Our Ref: R/187/17/HH

**Town & Country Planning Act 1990 (as amended)
Town & country Planning (Development Management Procedure) (England) Order 2015
Application for Planning Permission for Works or Extension to a Dwelling**

Development First floor side extension
Location 48 Dinsdale Gardens Rustington

ELEVATIONS.

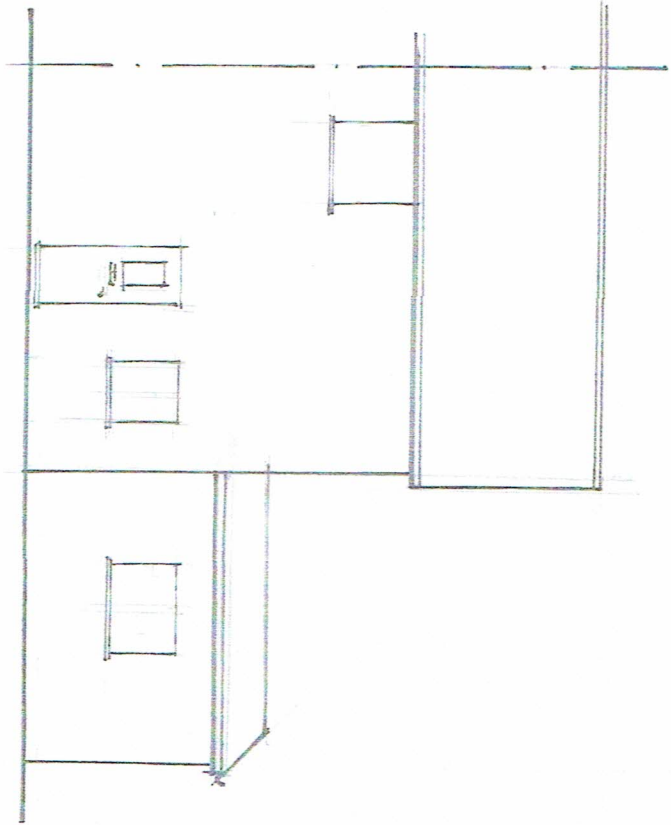
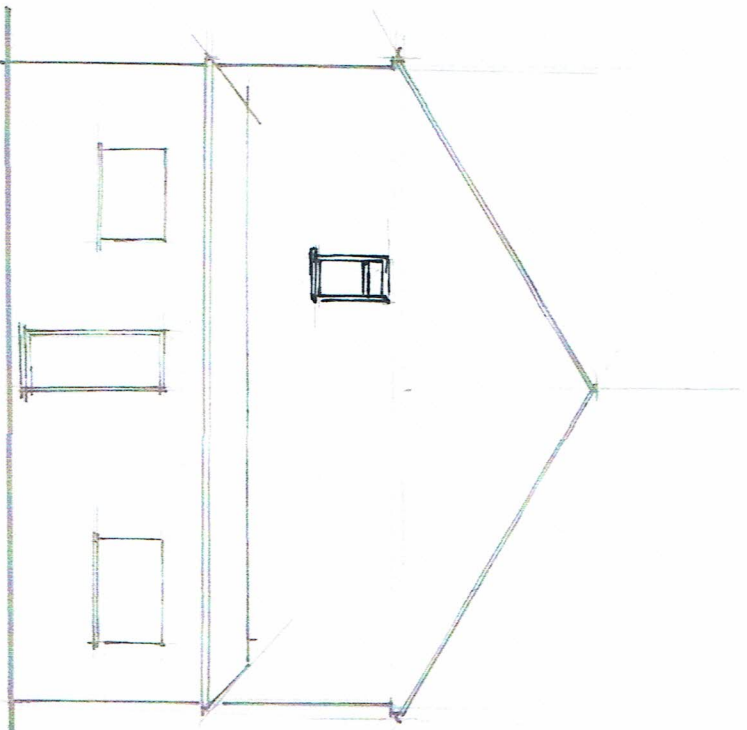
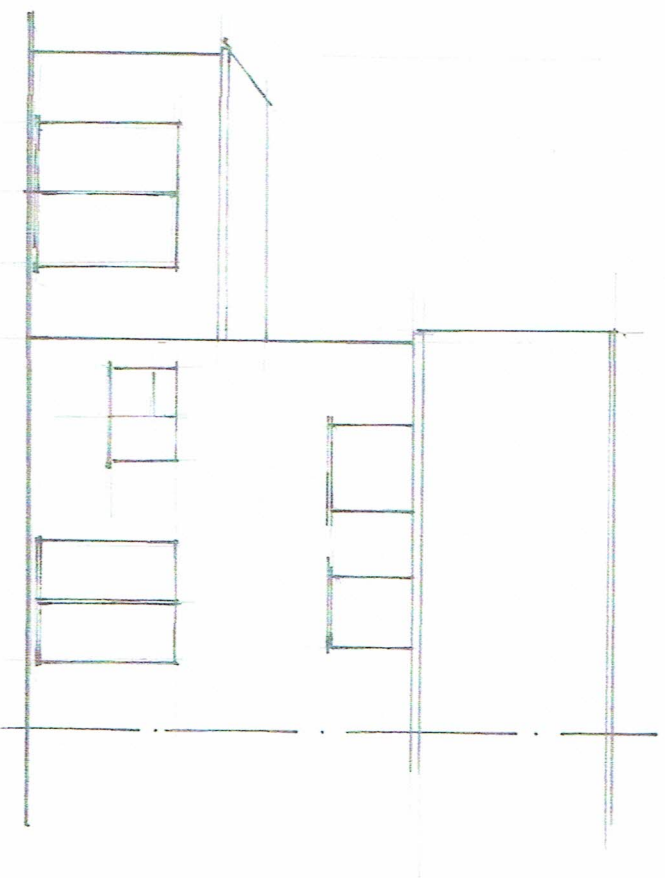
The existing north first floor plan and elevation do not accord. Please amend accordingly.
